RE: Harnett County Land Use Existing Tank Application #BRE1807-0025
245 Atkins Place Circle ~ Lt 2. Atkins Place

Based on the criteria set out in Title 15A, Subchapter 18A, of the North Carolina Administrative Code, Rules .1950, the evaluation indicated that the site is **UNSUITABLE** for. Therefore, your request for an existing tank is **DENIED**. The site is denied based on the following:

IMPROVEMENT PERMIT

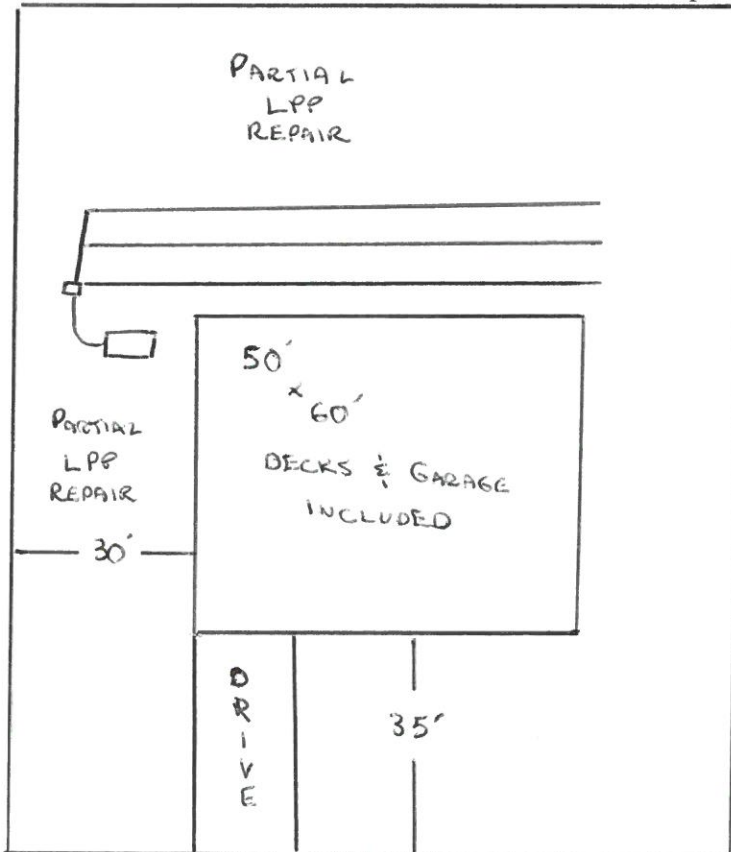
- 15A NCAC 18A.1950a {16} - Any swimming pool must be 15' from any part of septic system.
- 15A NCAC 18.1945{b} - Each lot shall have original septic system plus repair area.
- 15A NCAC 18A.1950 {10} - Any building to be 5' from septic tank and/or from drain line. Proposed deck within septic area. Revision required meeting setback. No fee.
- 15A NCAC 18A.1950{c} - Nitrification fields and repair areas shall not be located under paved areas or areas subject to vehicular traffic.
